WEST SUSSEX COUNTY COUNCIL CONSULTATION

TO:	Arun District Council FAO: Michael Eastham
FROM:	Highways, WSCC: Tim Townsend
DATE:	10th October 2018
LOCATION:	Phase 2 Land North of, Toddington Lane, Wick, Littlehampton, West Sussex, BN17 7PP
SUBJECT:	LU/240/18/PL Variation of condition 1 imposed under LU/121/17/RES relating to approved plans.
DATE OF SITE VISIT:	N/A
RECOMMENDATION:	☒ Advice ☐ Objection ☐ Modification ☐ No Objection ☐ More Information ☐ Refusal
S106 CONTRIBUTION TOTAL:	£N/A

Drawing Title:
LOCATION PLAN - 124 Units

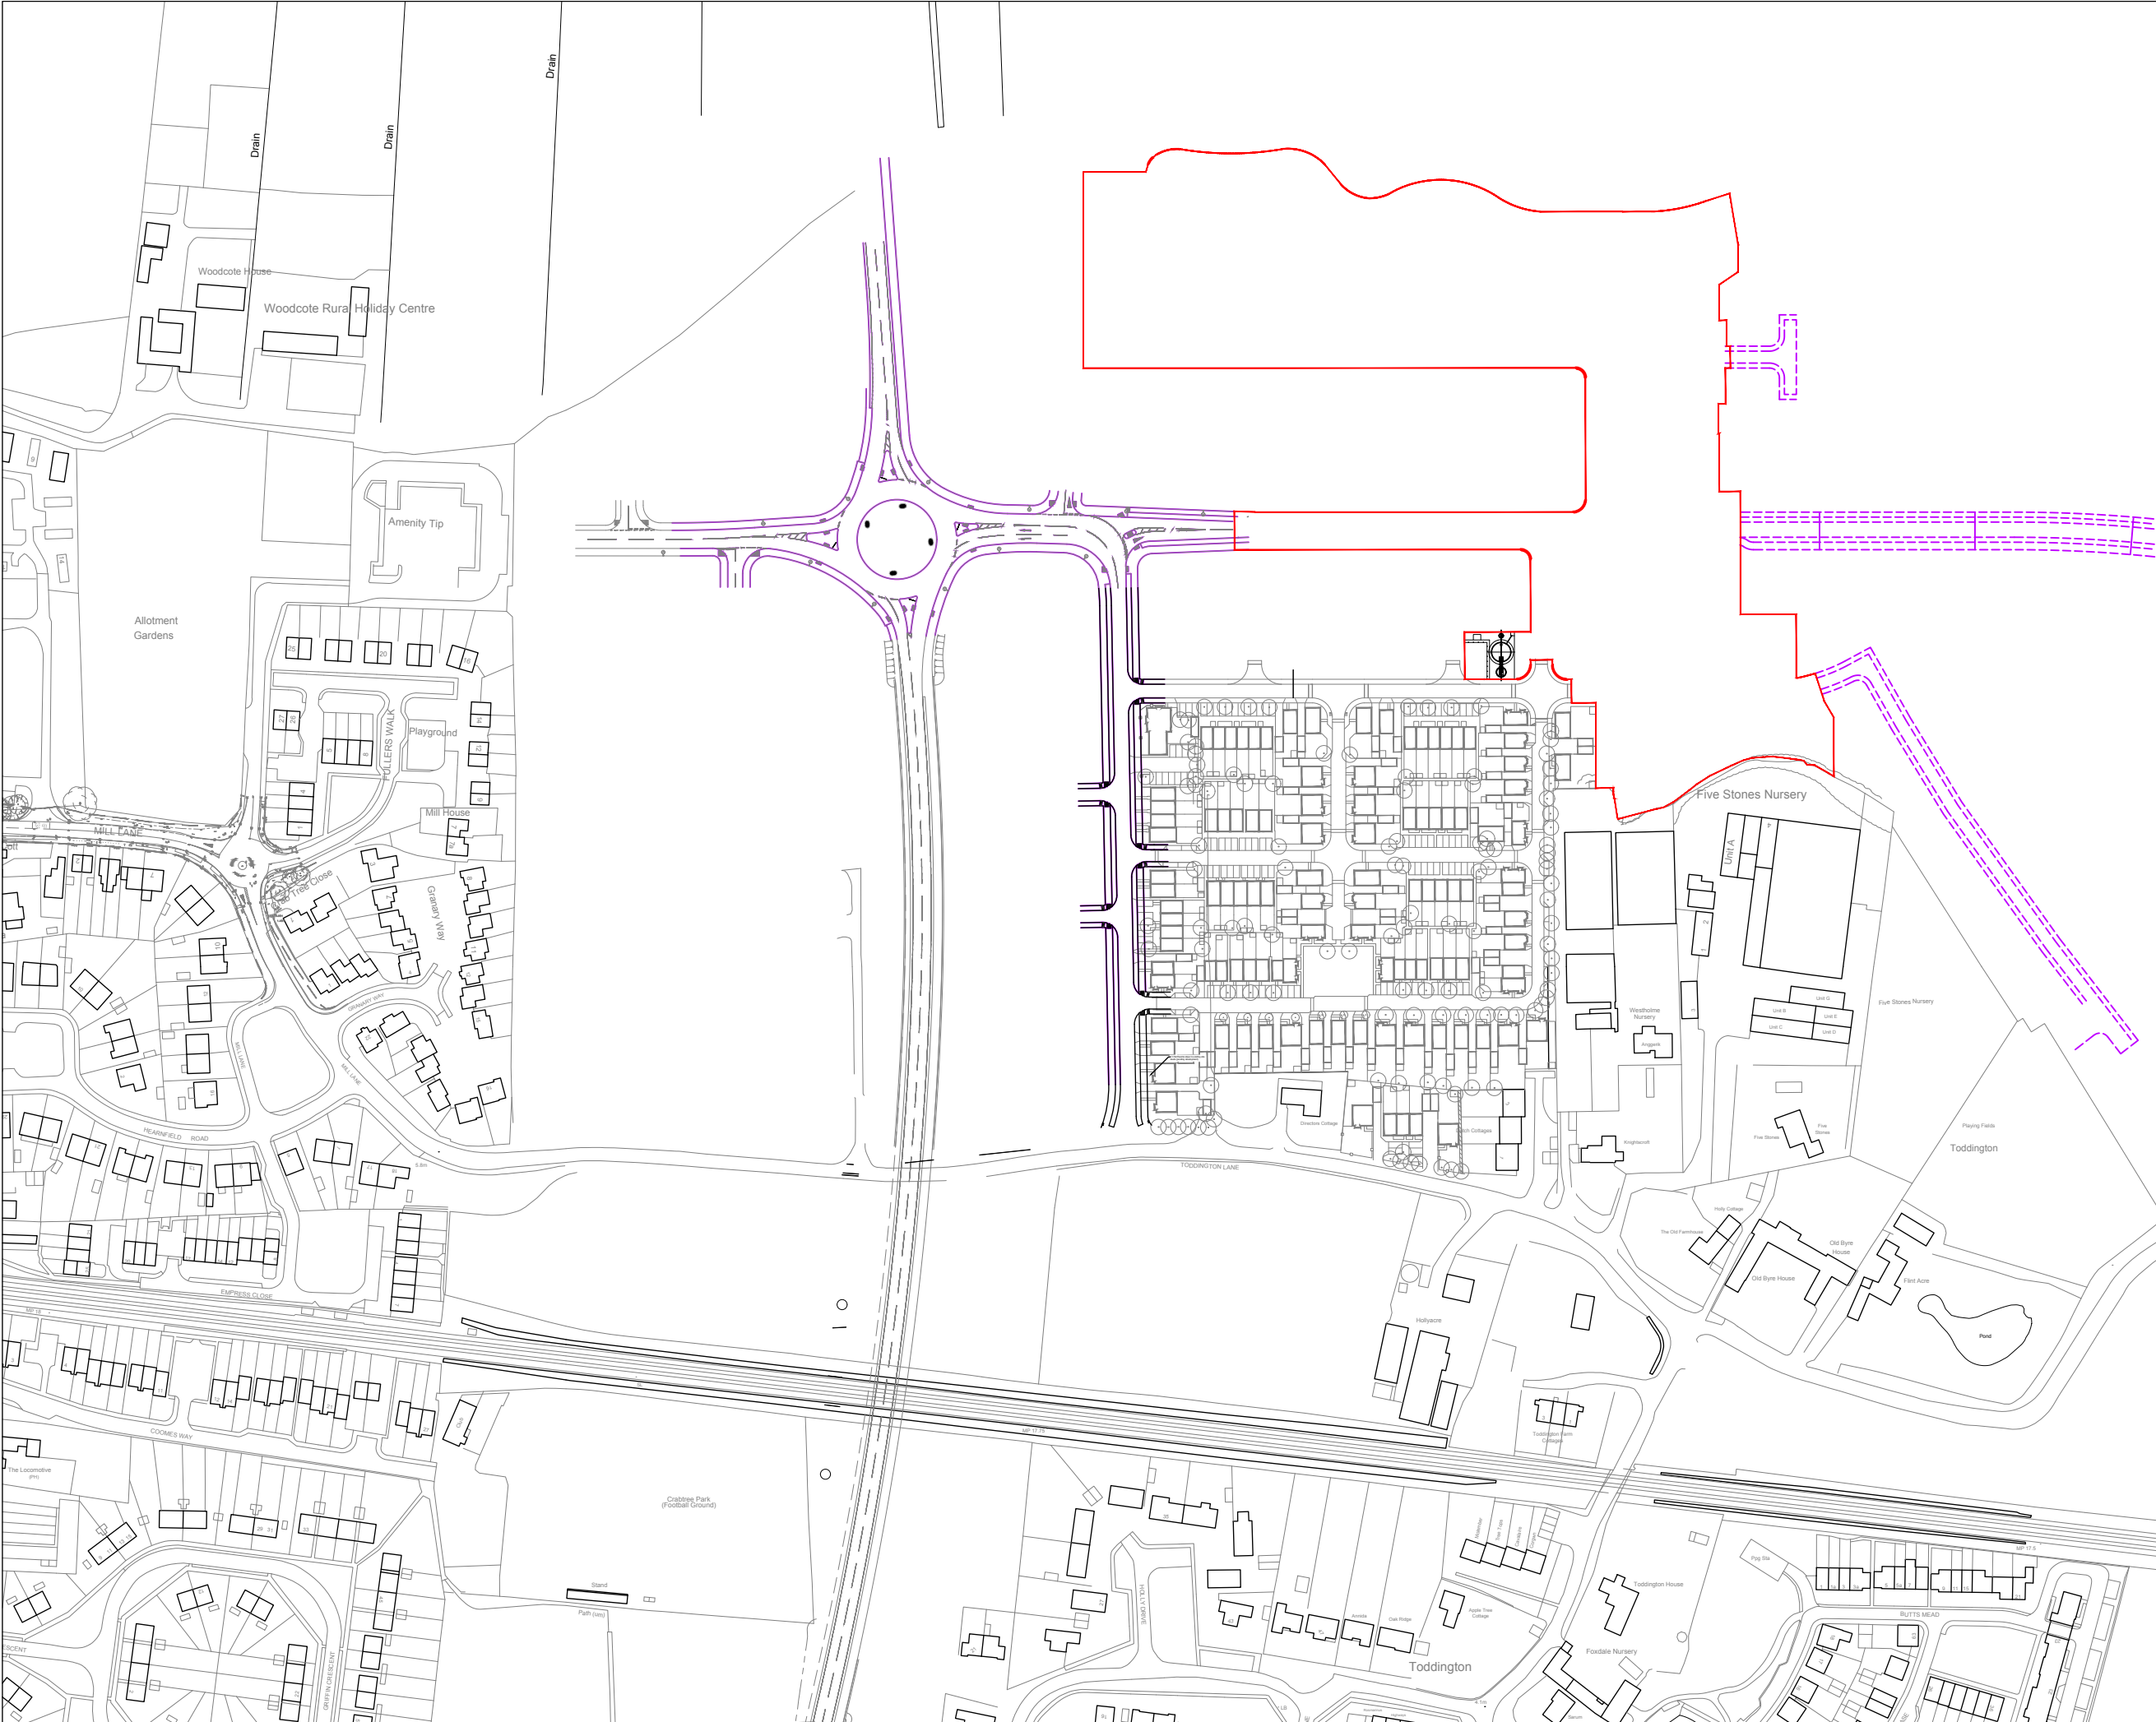
1. Amendment to the red-line (southern boundary) – *For LPA to consider.*
2. Loss of 2 units (affordable) from the approved 126 unit scheme. Phase 2 will now comprise 124 units – *For LPA to consider.*
3. Re-design of the LEAP based on boundary amendment and levels – *for LPA to consider.*
4. Removal of garage for plot 38 – now a parking space – *No LHA objection.*
5. Landscaping scheme updated – ***** Comments to follow *****
6. Engineering drawings revised in relation to the boundary and levels with the inclusion of retaining walls – *For LPA to consider.*
7. Affordable house types affected due to removal of 2 units – *For LPA to consider.*
8. Bin/cycle store for apartment block A (plots 95-100) moved slightly eastwards to accommodate substation parking provision for maintenance – *No LHA objection.*
